DELEGATED DECISION

Address: TOWNEND FARM HILL END ROAD HAREFIELD

Development: Conversion of agricultural building to one dwelling house with associated building operations including new windows, doors and roof lights (Application for Prior Approval under Schedule 2, Part 3, Class Q of the Town and Country Planning (General Permitted Development) (England) Order 2015 (as amended)).

LBH Ref Nos: 76981/APP/2023/1033

02 Proposed Barn Plan and Elevations
1:100

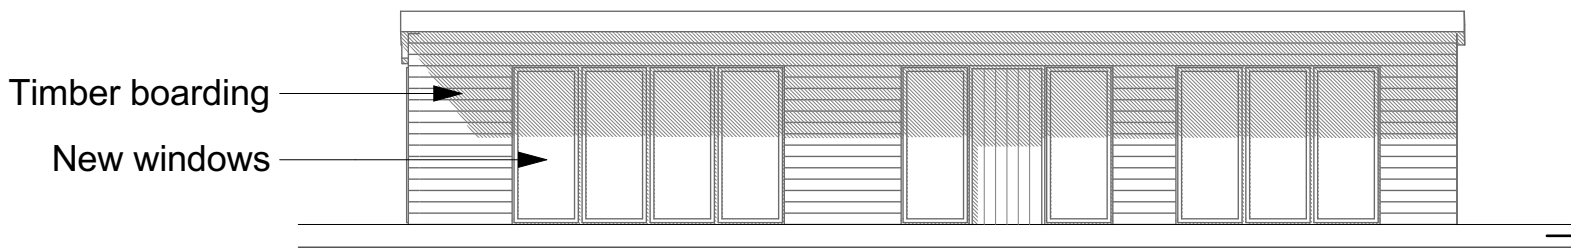
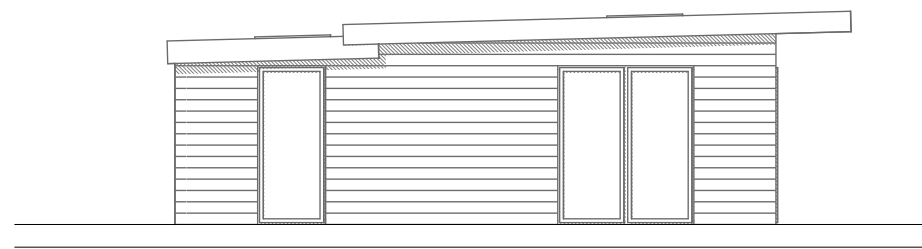
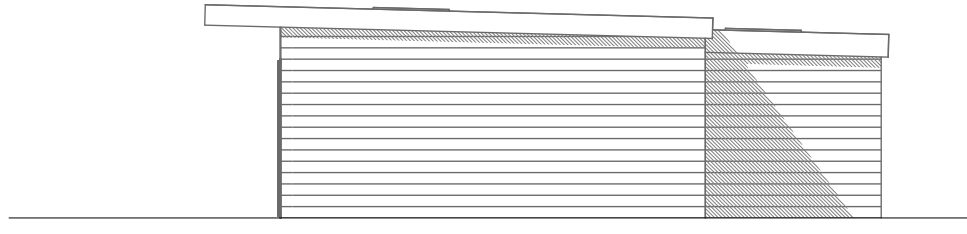
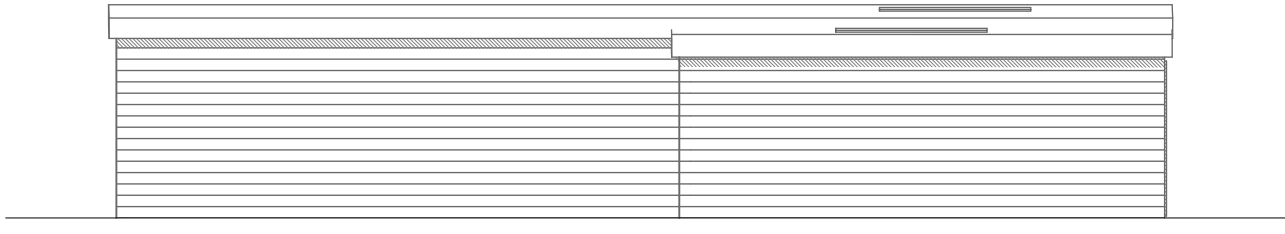
The proposal includes the installation/replacement of windows, doors, roofs and exterior walls of the existing barns. Whilst it is noted that individually these identified proposed works would not fall outside of the operations given in paragraph Q.1(i), this does not necessarily mean that cumulatively such operations could not go beyond what would be considered 'reasonably necessary' for the conversion of the buildings.

An Engineers Report has been submitted as part of this application, and based on the information provided, it has not been demonstrated to the satisfaction of the Local Planning Authority that the building is structurally capable of being inhabited as a dwelling. Nor has any robust information been provided outlining the degree of building work that would be required to complete the development. It is noted in the Engineers Report that no further ground investigation has been carried out at this time and that the existing barn is performing adequately for its current purpose. However, it is questioned whether the existing foundations/footings of the barns could support such building works without any significant structural interventions. No structural calculations have been submitted to demonstrate otherwise.

In light of the above, and when considering the totality of the work, it cannot be ascertained that the building operations which would go beyond those considered reasonably necessary for the buildings to function as a dwellinghouse would not be required. The proposed development therefore fails to comply with the terms of permitted development rights paragraph Q.1(i), Class Q of the GPDO.

The site is also within Green Belt. The construction of new buildings within the Green Belt should not be approved except in very special circumstances. The proposal includes the installation/replacement of windows, doors, roofs and exterior walls of the existing barn. Given the totality of the proposed alterations, it is questionable as to whether the development would constitute a new building. Some exceptions to the construction of new buildings are outlined in paragraph 149 of the National Planning Policy Framework. In the absence of any detailed information or clarification, it is undetermined whether the proposed works would constitute and alteration to a building (para 149c) or a replacement building in a different use (149d), the latter of which would be Inappropriate Development, and therefore harmful to the Green Belt.
